Project Name:	IMT Rail Capacity Improvements	Project ID:	2017-261
Address:	460 W Commercial St	CBL:	059-A-001
Applicant:	Maine DOT		
Planner:	Matthew Grooms

On January 26, 2018, the Planning Authority approved with conditions an amended Level III Site Plan for staff review (2017-261) for proposed rail capacity improvements which include installation of two segments of track; a 750 foot siding track that will run parallel with existing siding along the concrete loading slab at the western extent of the International Marine Terminal (IMT) site along West Commercial Street, and a 1,100 foot extension to the existing runaround track immediately east of Cassidy Point Drive. The proposed improvements are located within the Waterfront Port Development Zone and will serve the IMT. The Planning Authority reviewed the proposal for conformance with the standards of the Site Plan and Shoreland Zoning Regulations to approve the application with the following conditions as presented below:

RE: Staff Review Comments for 460 Commercial Street – IMT Rail Capacity Improvements
(2017-261) – Planning Authority Review

**EROSION & SEDIMENT CONTROL PLAN**  
1" = 50'

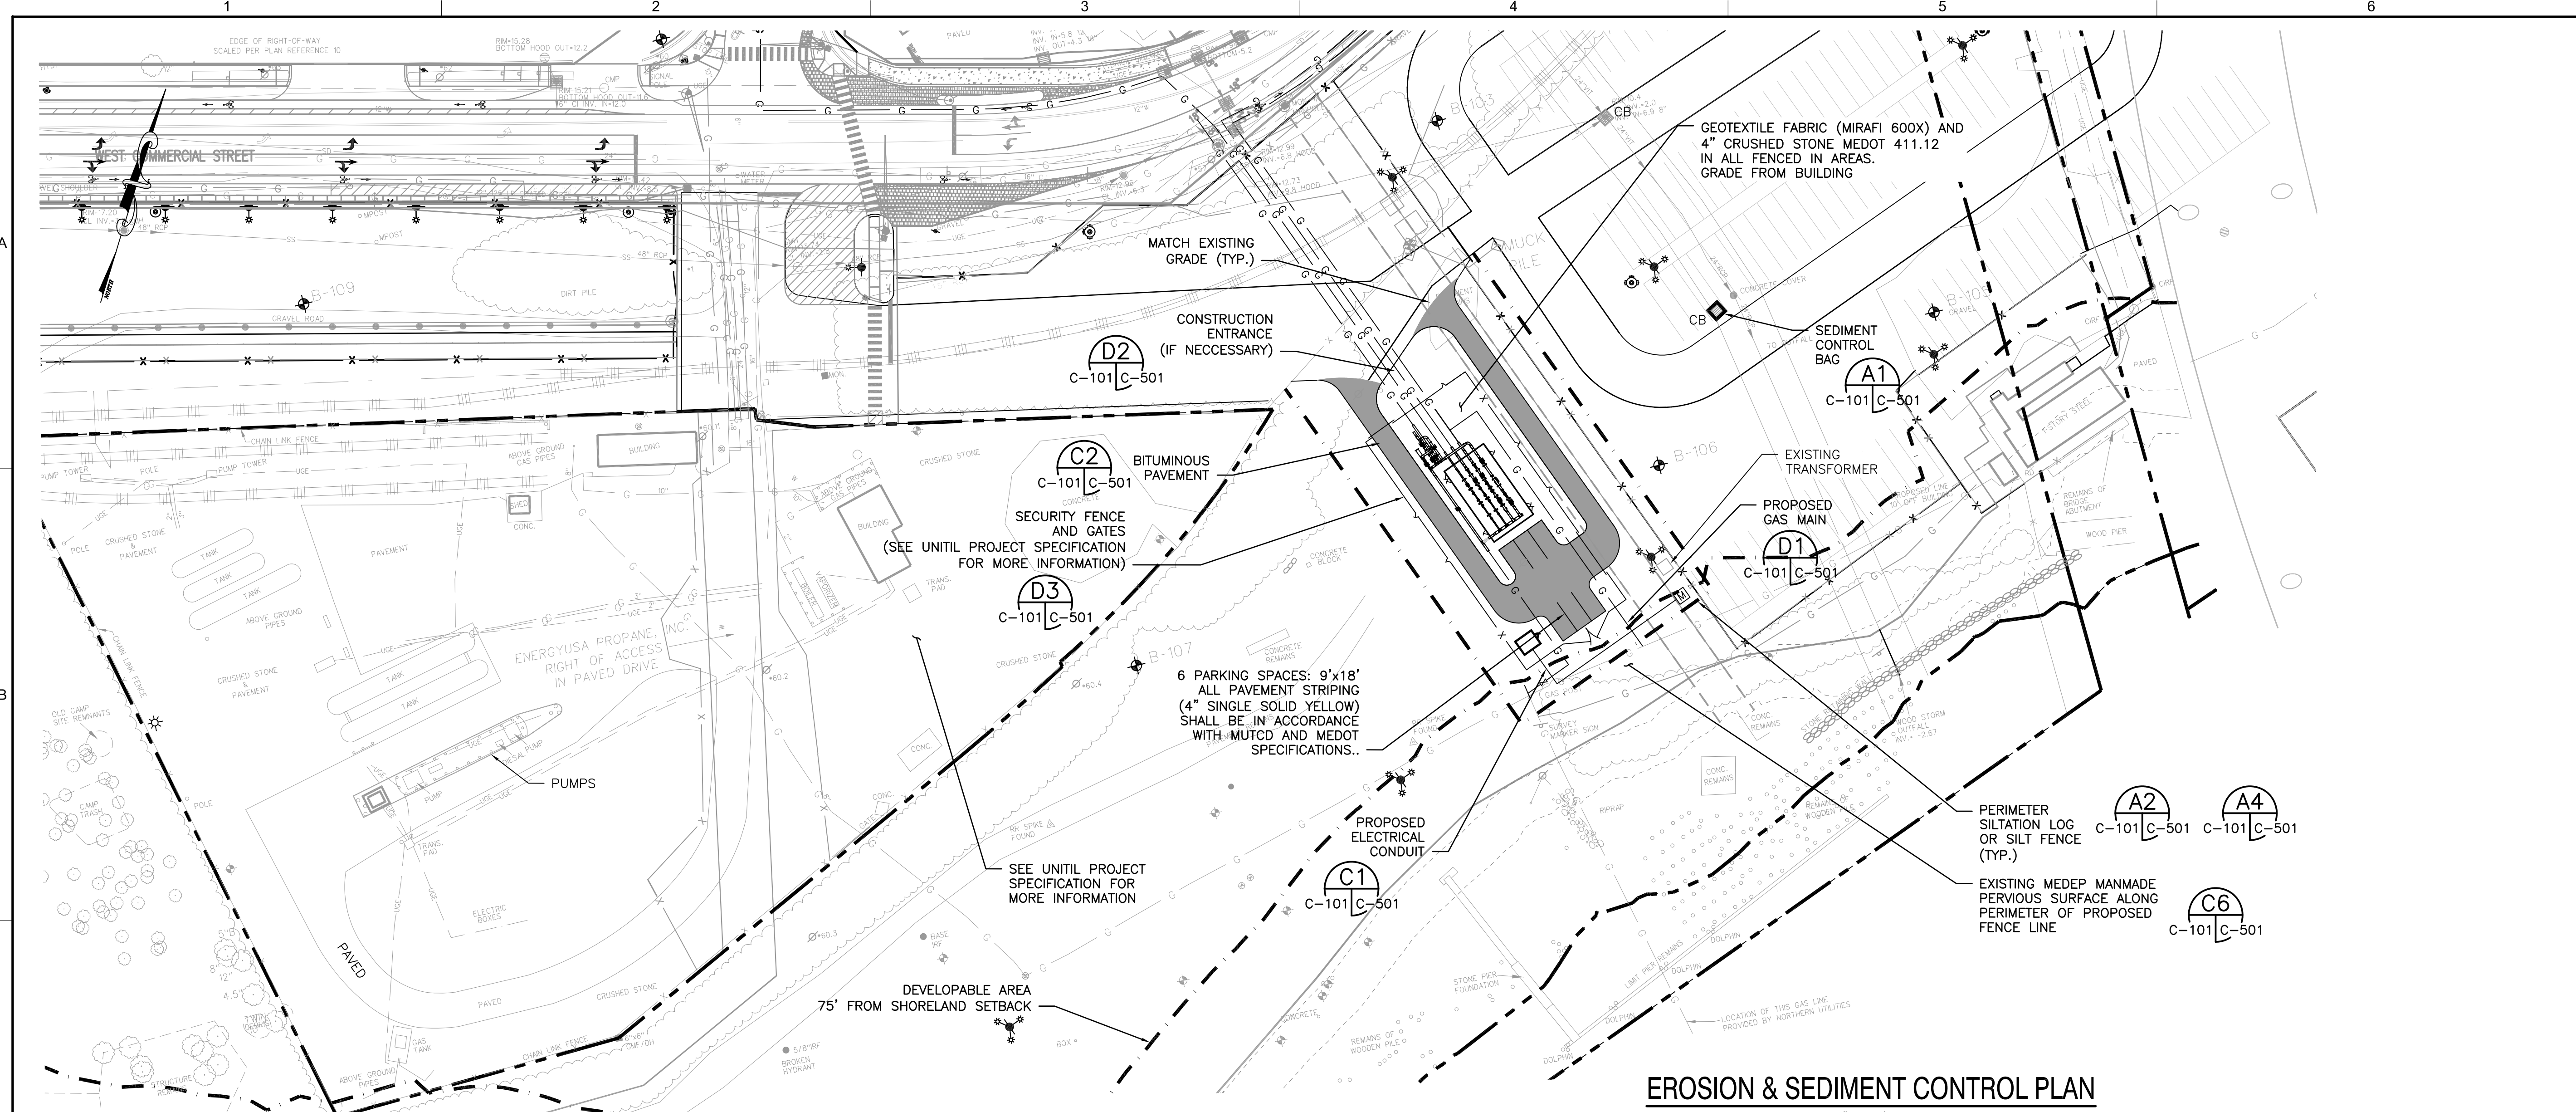
1. The applicant shall provide an Erosion and Sediment Control Plan for review and approval by the Planning Authority.

They should provide an erosion and sedimentation control plan, however. Their application notes that the ESC narrative remains unchanged from their prior submission. The plans should reflect sedimentation barriers surrounding any disturbed areas, especially on the water side, and all existing basins and culvert inlets/outlets should be protected as well with sediment barrier, hay bales, or silt-sacks as appropriate.
